Planning application 20/01933/F Comment from Wigginton Parish Council

16 September 2020

A - THE MEADOW

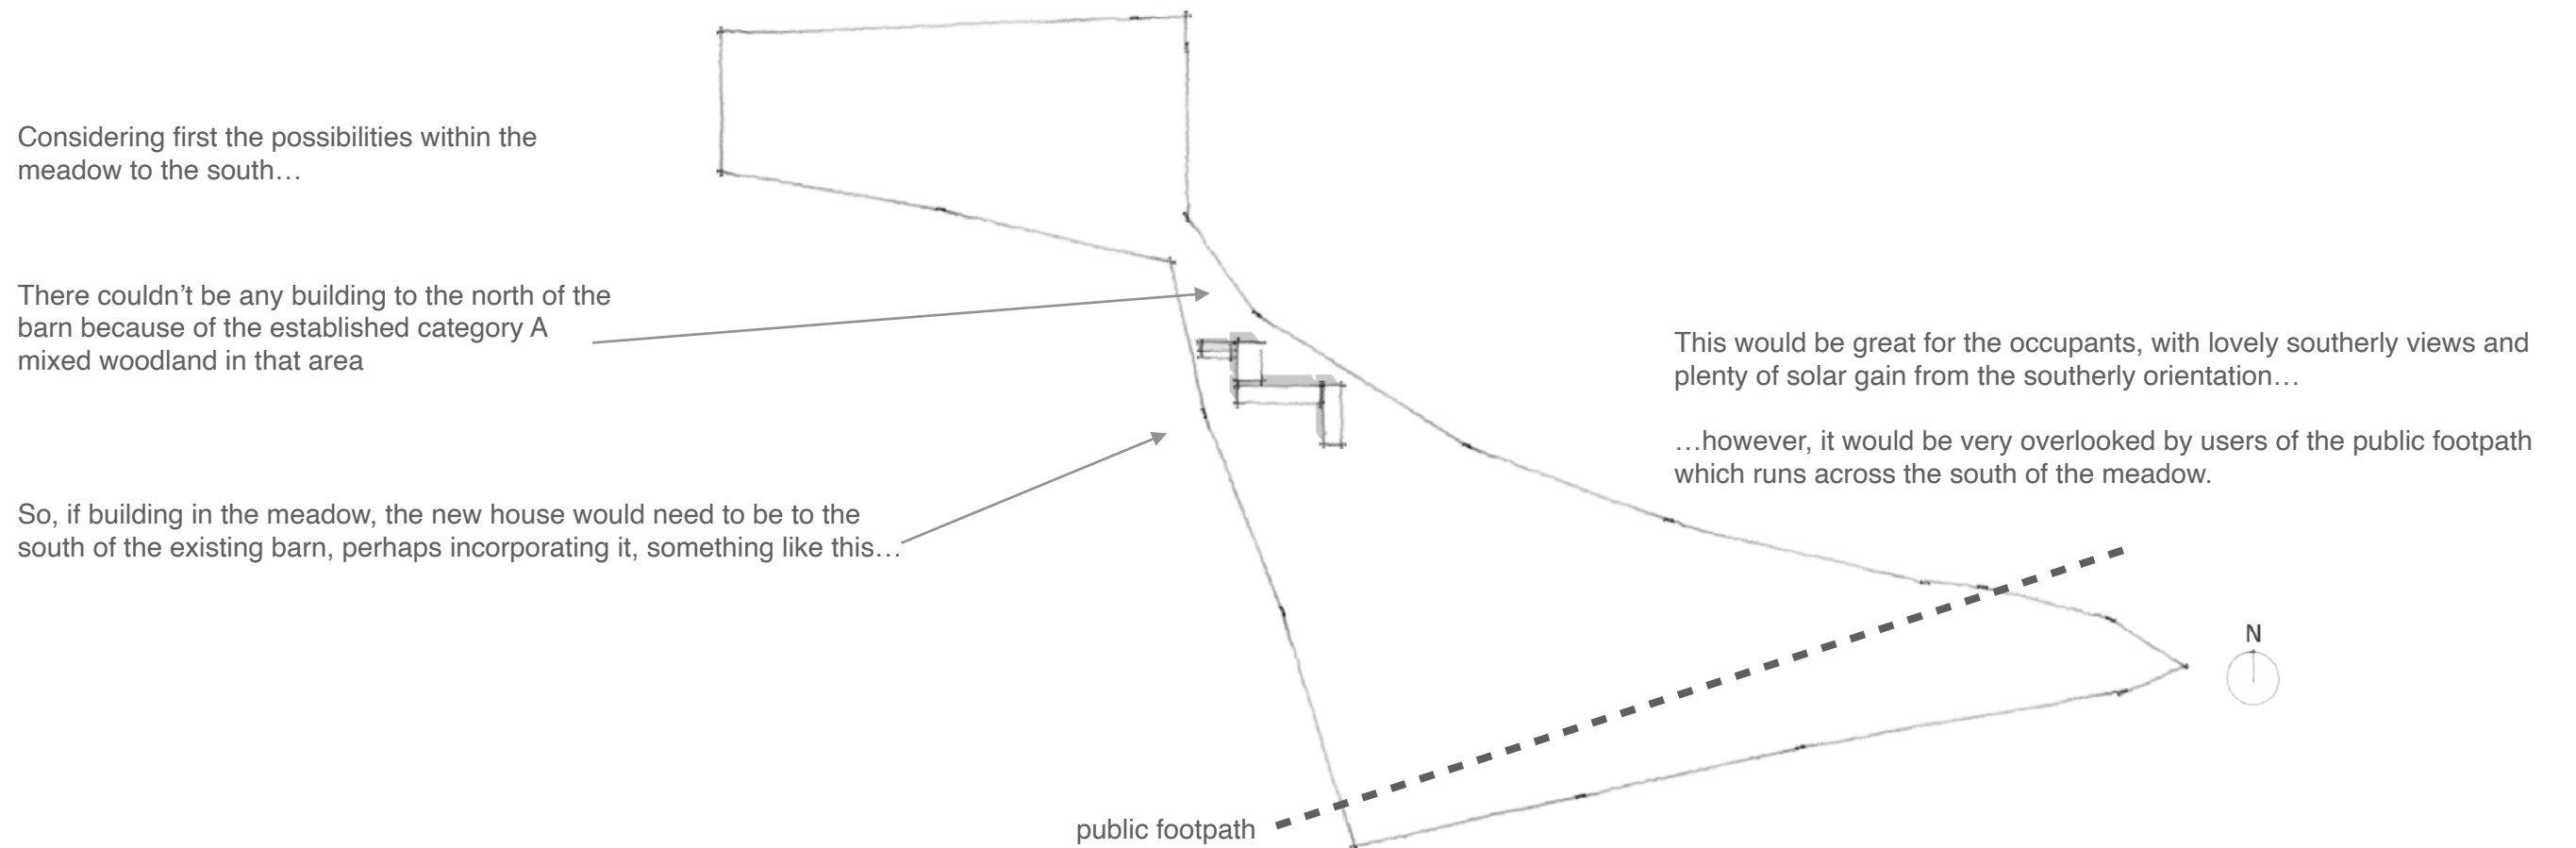
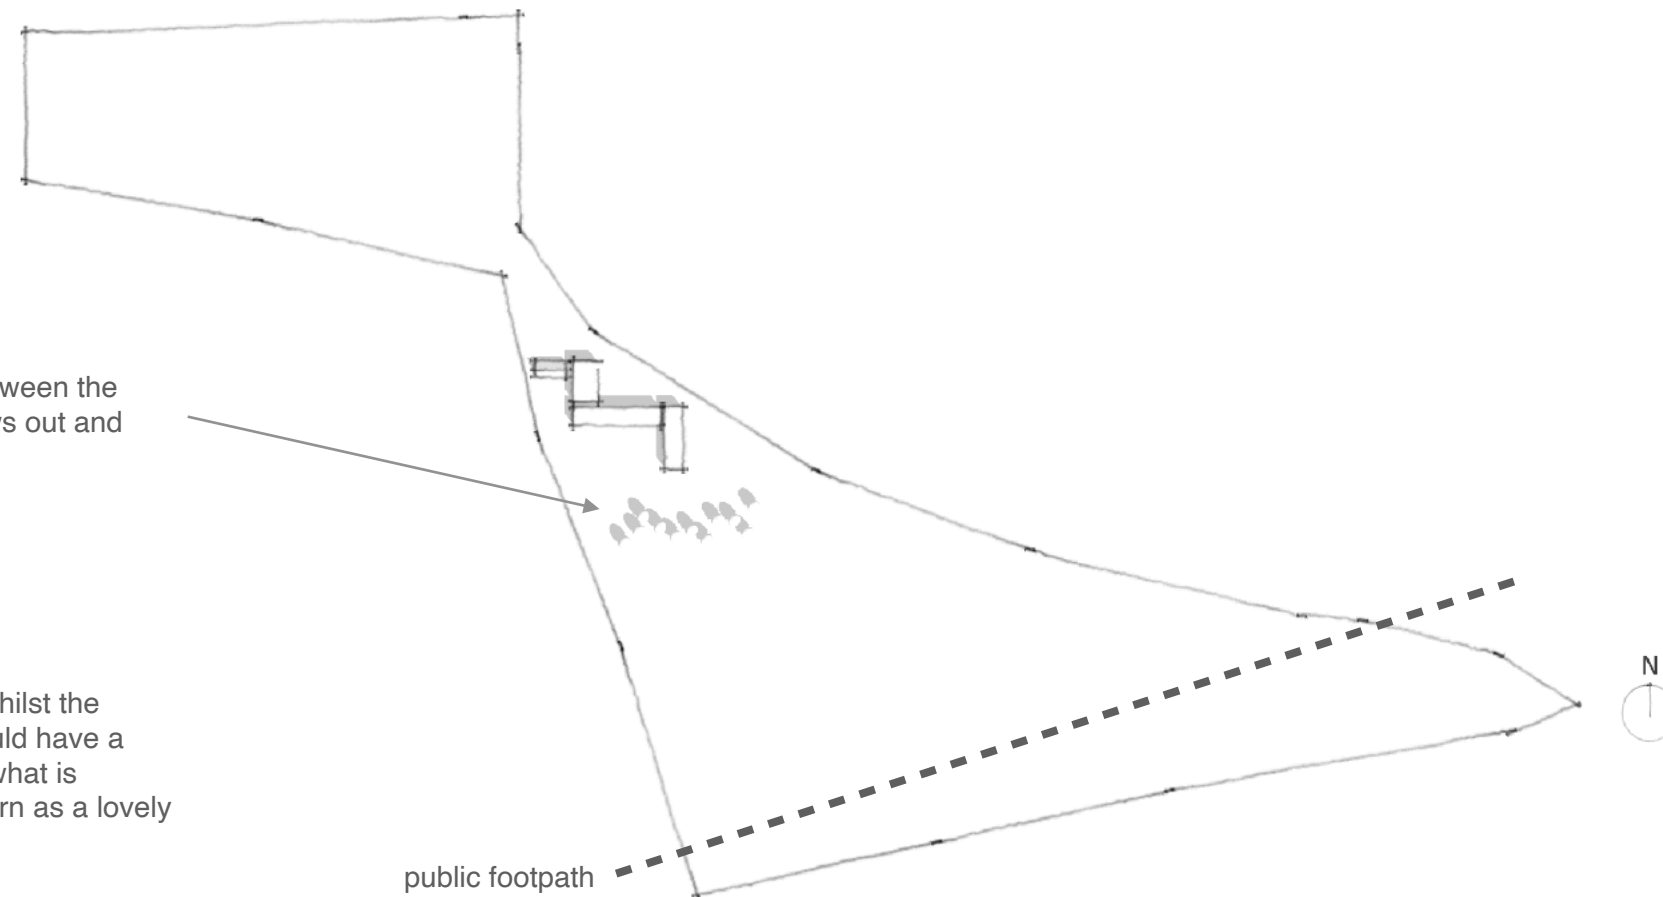
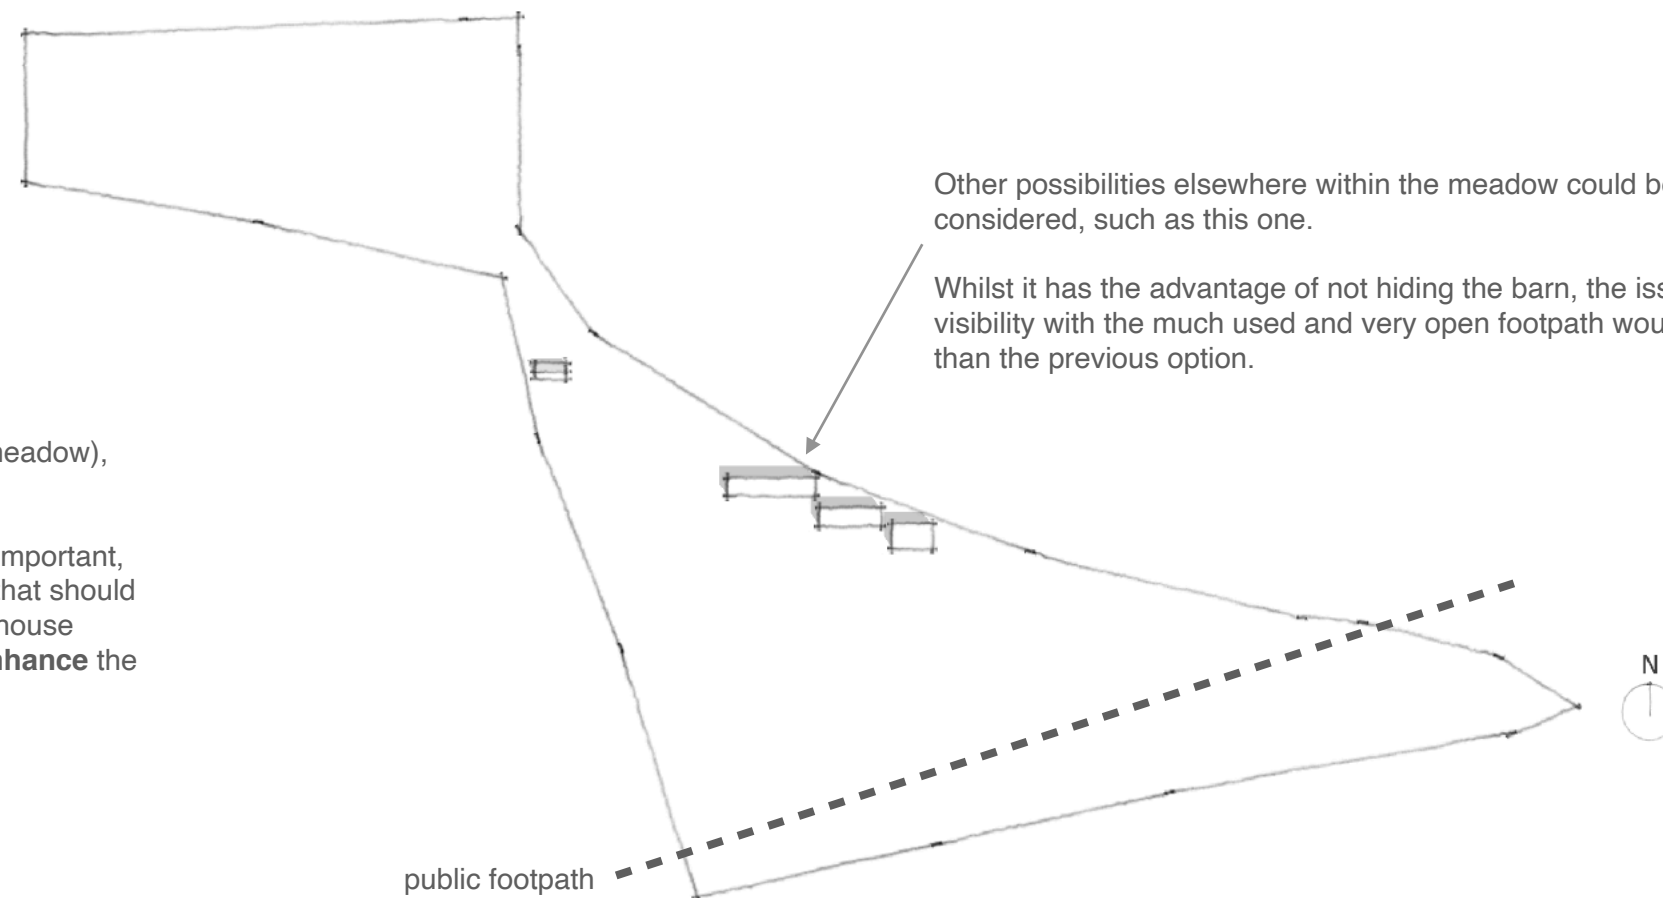
It is proposed to lay the hedge to the south of the buildings to open up the view which overlooks the Public Right of Way. This footpath is used by many villagers, locals and visitors who enjoy the tranquillity so rare today and the unspoilt nature of the valley which should be protected under Cherwell Policy ESD 13. It is important this is preserved for future generations. The buildings will be visible from the footpath but this is dismissed as being of 'No significance' and 'Neutral' to users; the Parish Council disagrees.

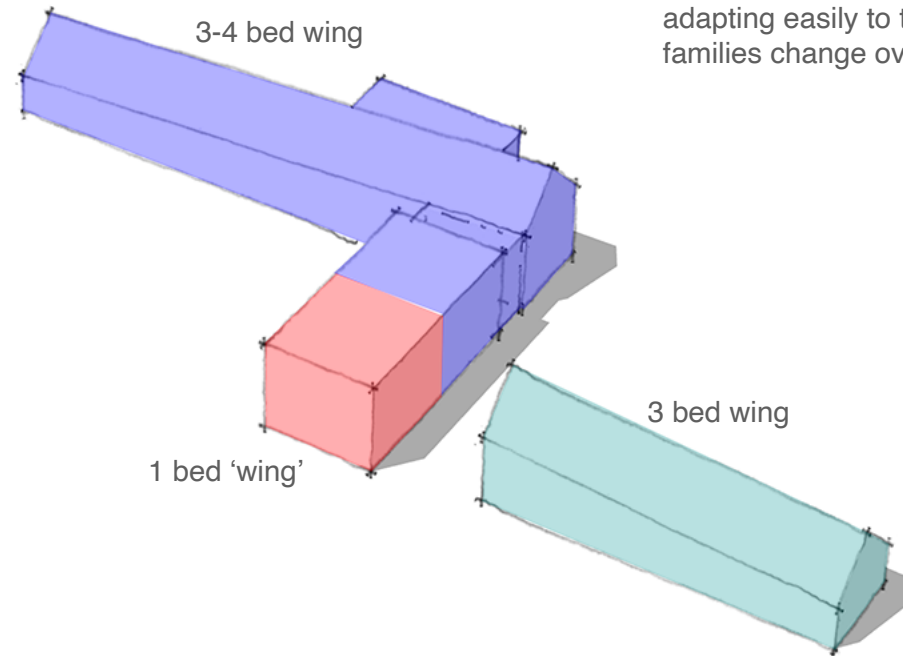
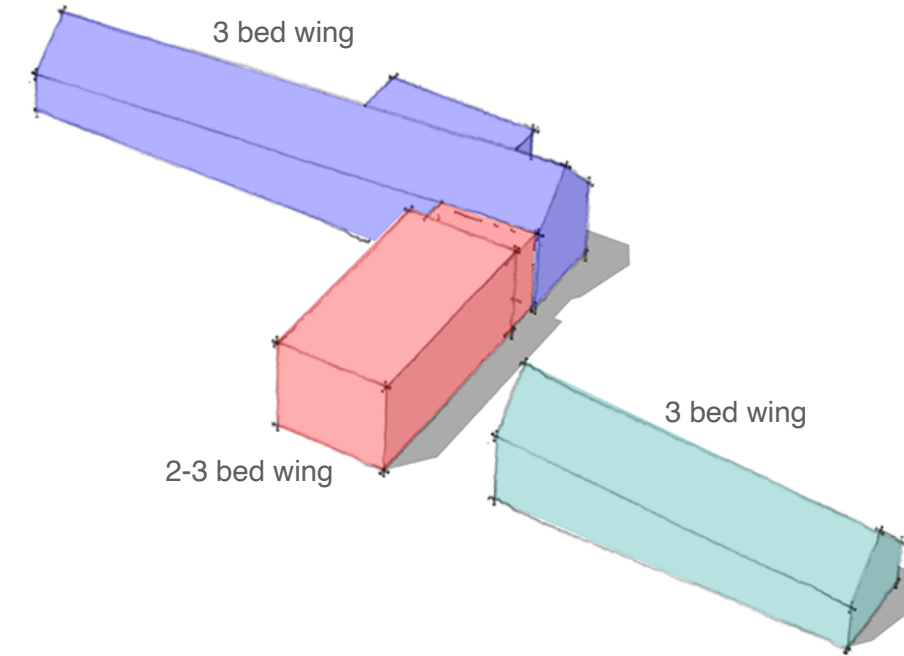
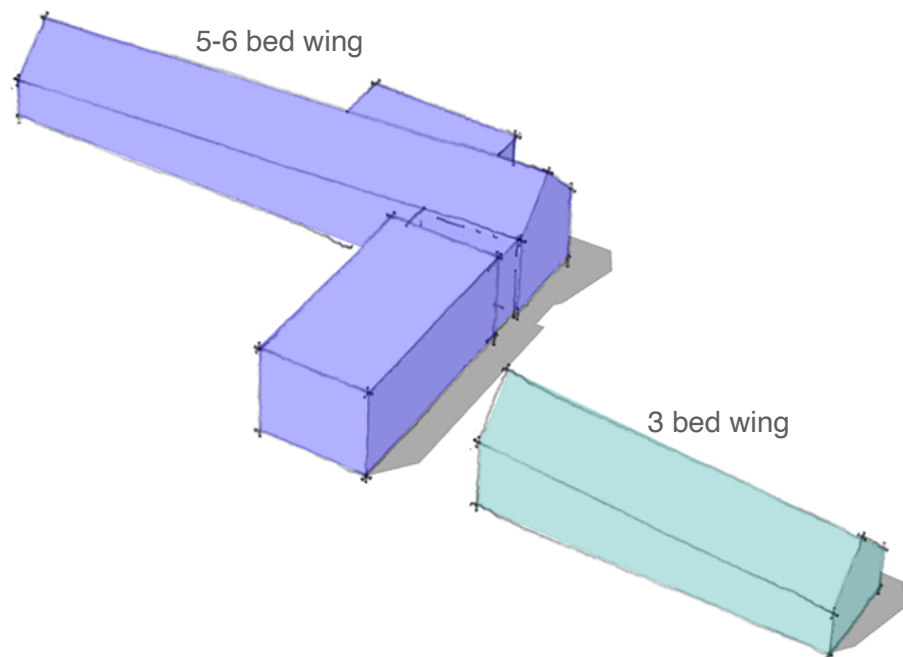
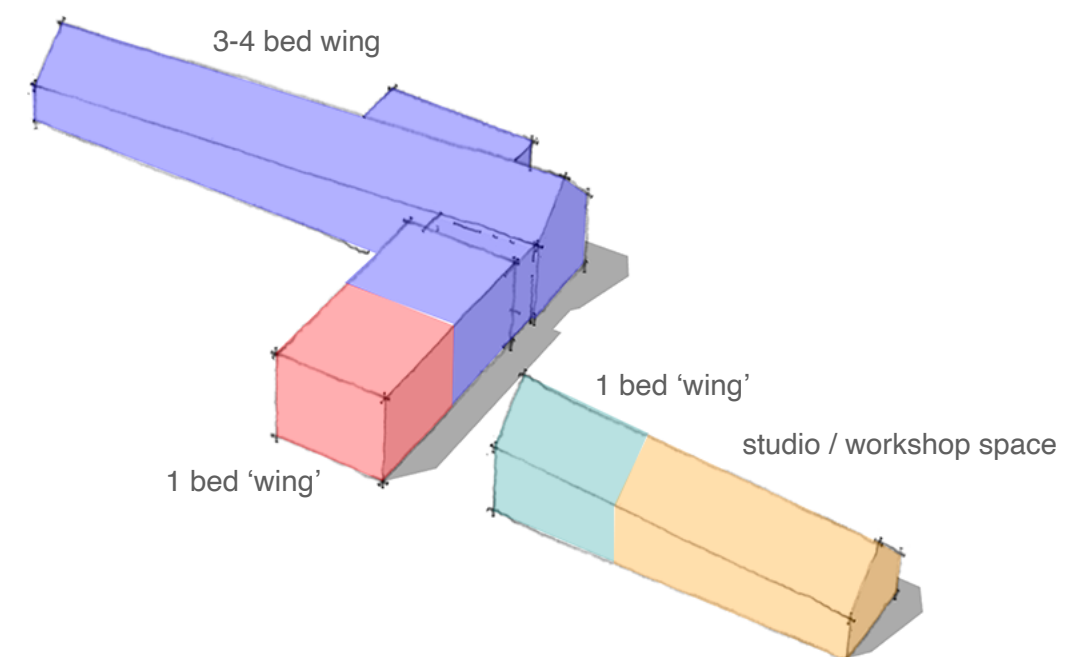
According to the National Planning Policy Framework (Feb 2019) a Para79 house is a single dwelling which is permitted in an isolated position. This application is clearly for three households with three large kitchens, three front doors and three separate terraces for outdoor seating. The measurement from the lake front to the back of the second house is over 80 metres and the height is up to 9 metres. They are referred to as the ‘three volumes’ in one supporting document, ‘three building elements’ in another. Two households are linked and the third is completely separate. They could simply be sold on as three separate dwellings.

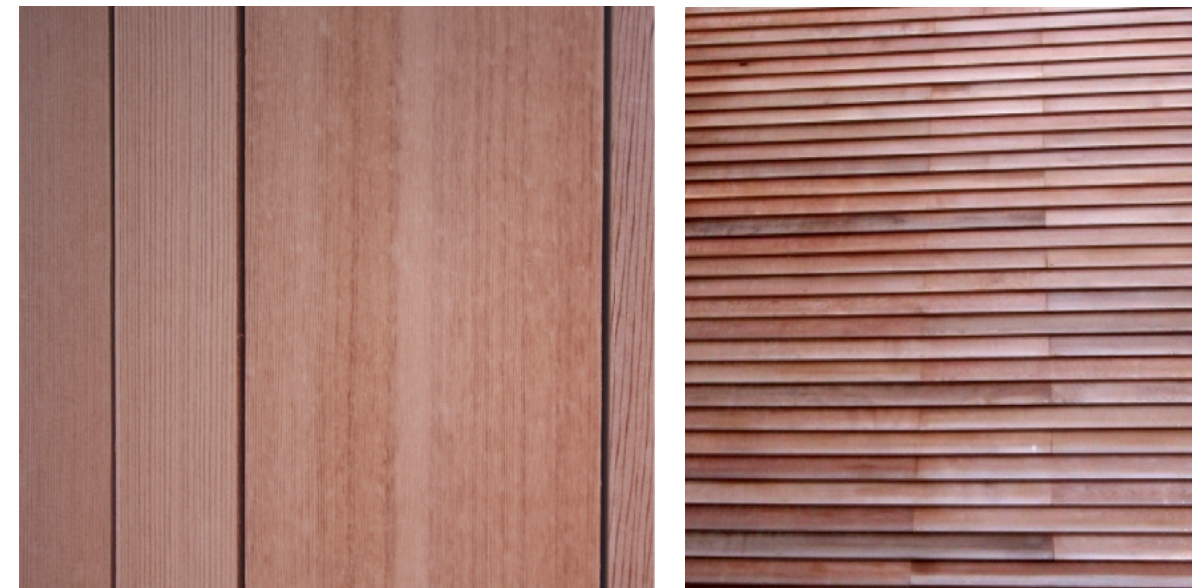
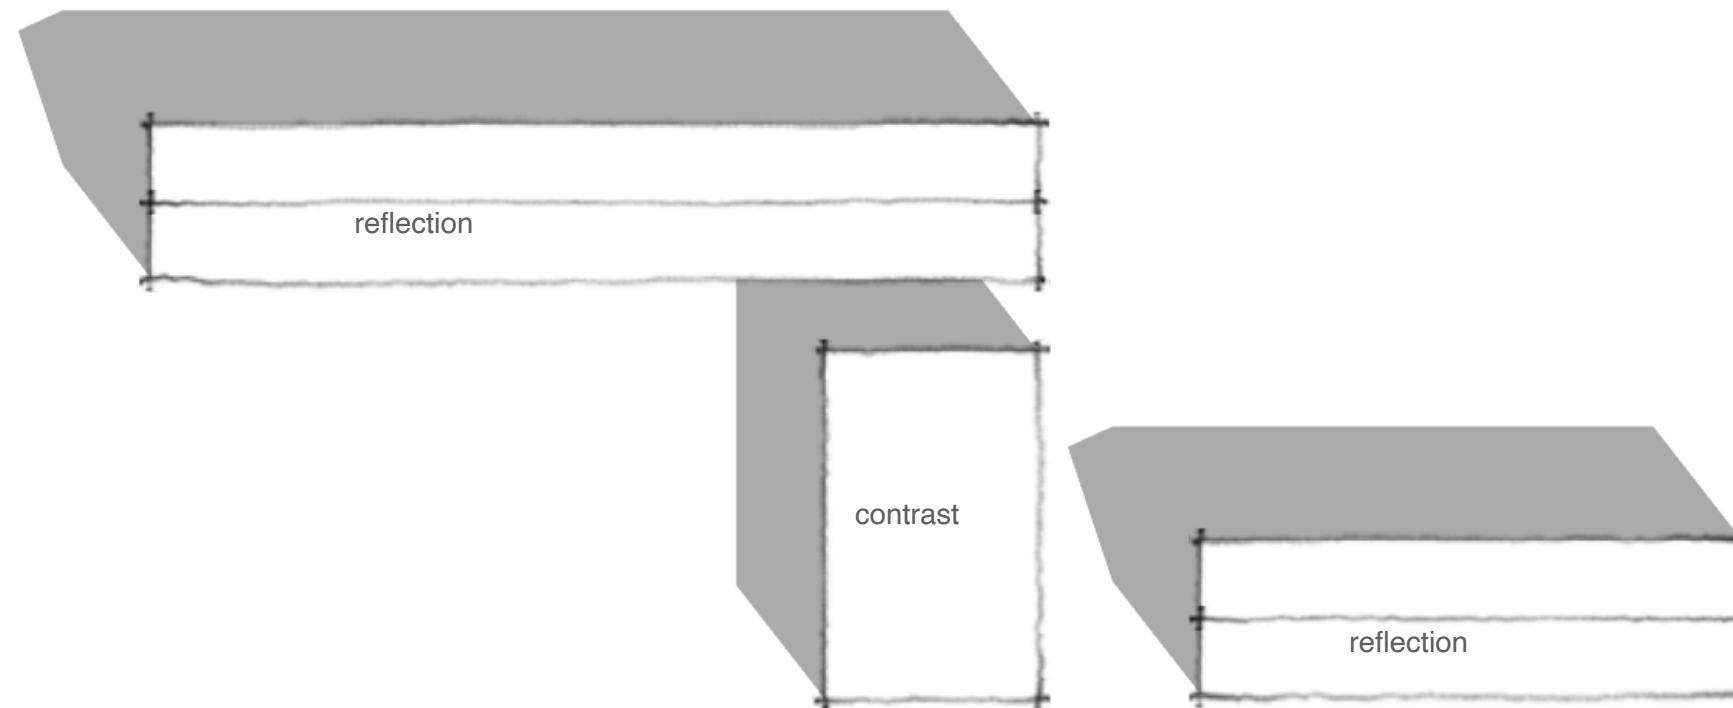
A Para 79 house should raise the standard of design and be sensitive to the defining characteristics of the area. There are several new houses in the immediate vicinity which fulfil these criteria but this is not one of them. Cherwell Policy ESD 16 demands respect for the area’s context. No one can doubt that ironstone buildings built in locally quarried Hornton stone are an integral part of this landscape and red cedar cladding is alien.
